Application Ref:	2026/0614			 Ribble Valley Borough Council www.ribblevalley.gov.uk	
Date Inspected:	N/A	Site Notice:	N/A		
Officer:	EP				
DELEGATED ITEM FILE REPORT:				Decision	PRIOR APPROVAL REQUIRED

Development Description:	Prior notification for proposed extension to an existing agricultural building to provide further space for cattle housing under Part 6 Class A of the GDPO.
Site Address/Location:	Rowan Bank Horton in Craven Horton Lancashire BD23 3JX.

Building Elevations

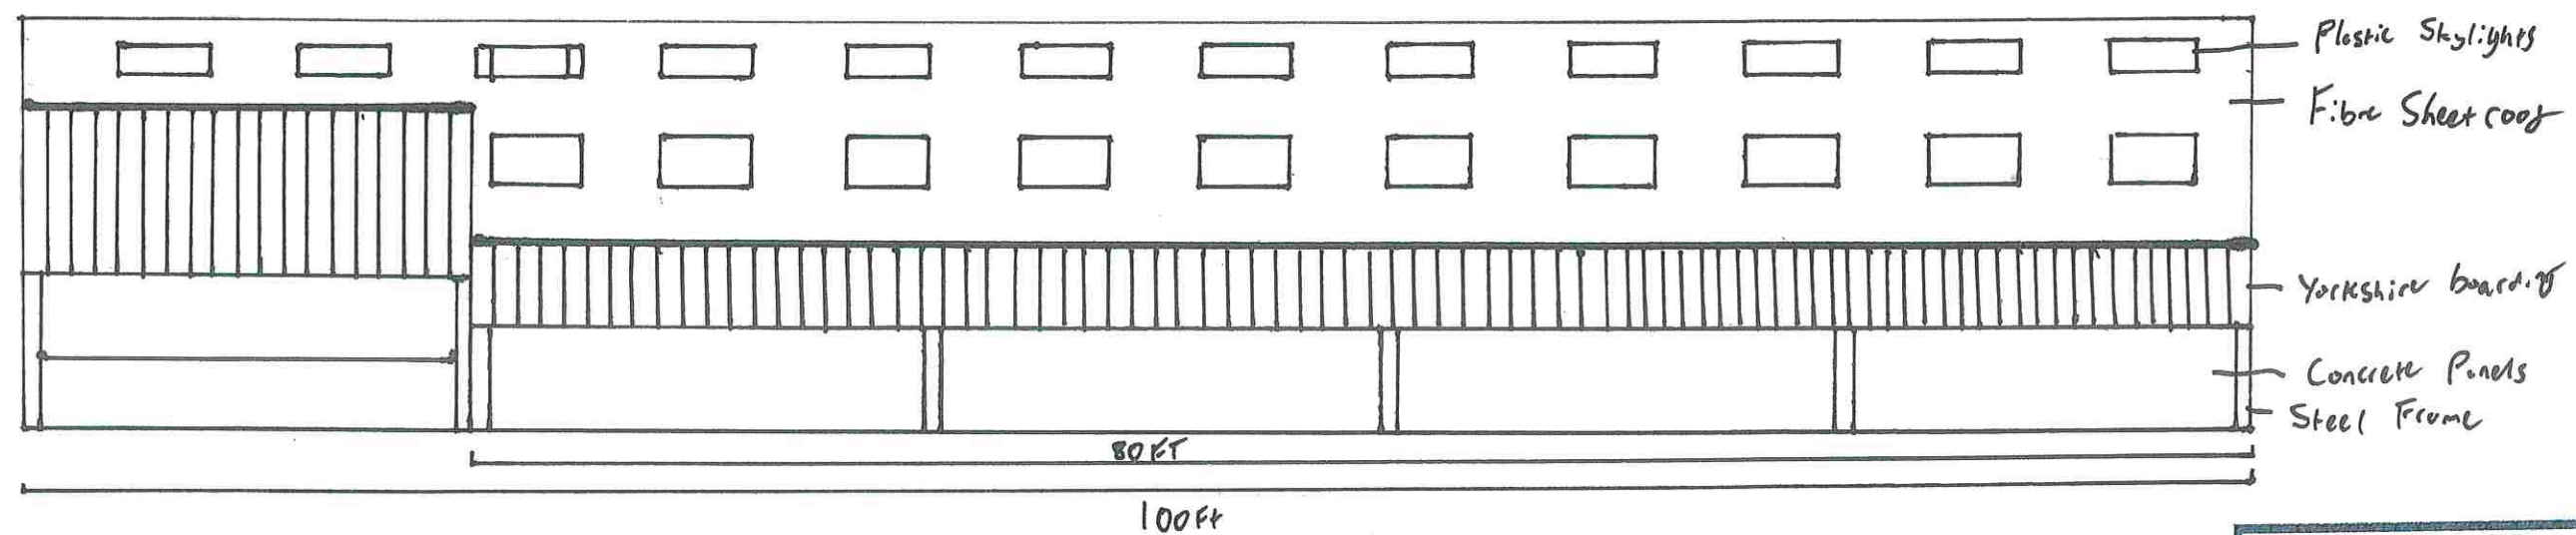
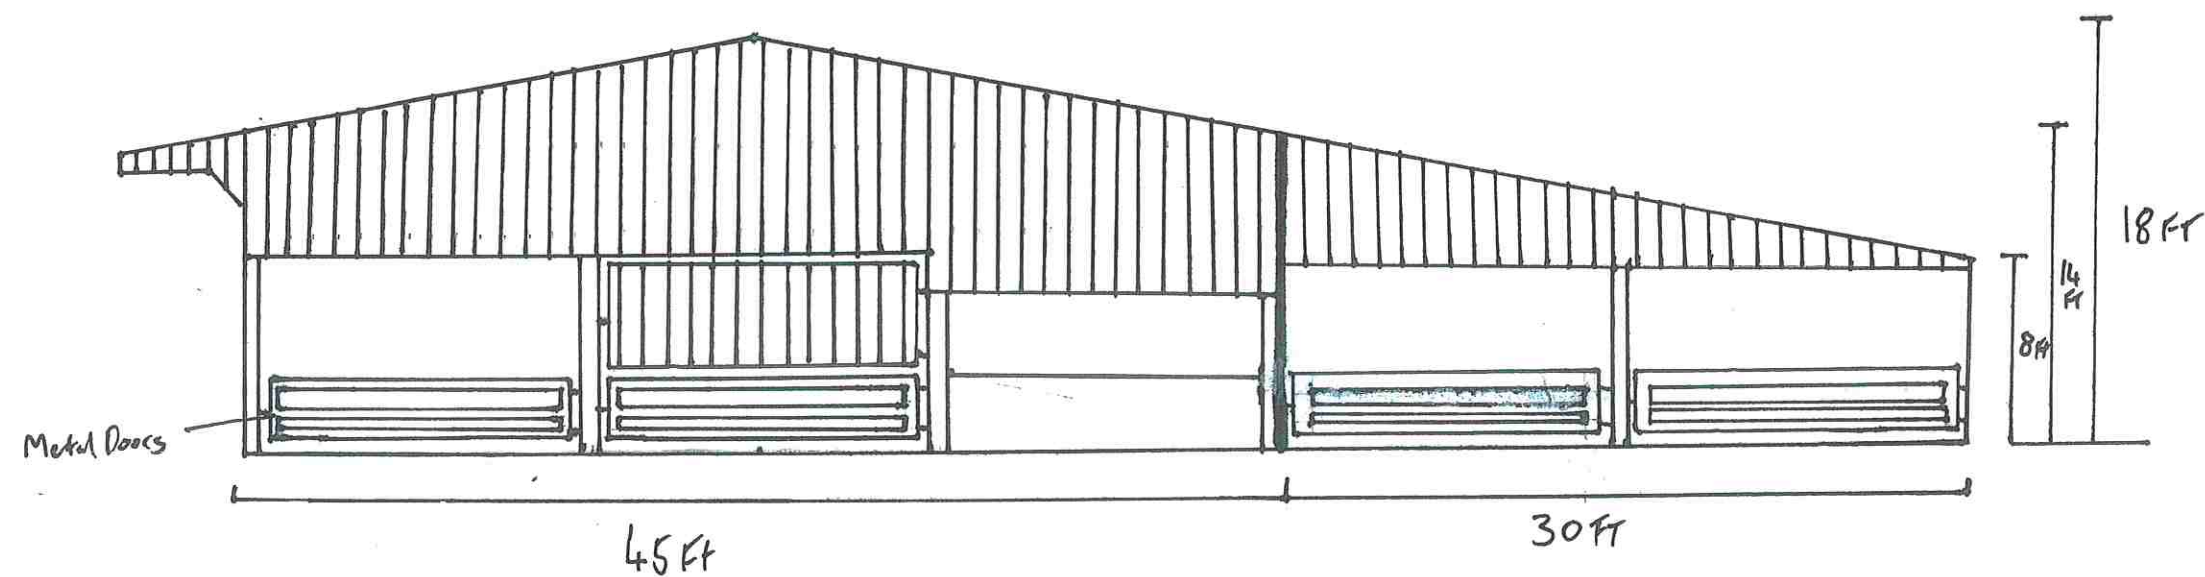
The proposed building would measure 5.5 metres in height to the ridge.

The proposed building will be constructed of a steel portal frame with concrete panels and Yorkshire boarding. This is consistent with typical agricultural buildings and others found within the farmstead, therefore the proposed building will integrate sufficiently and not harm the visual amenities of the area.

As such Prior approval is not required in terms of design and appearance.
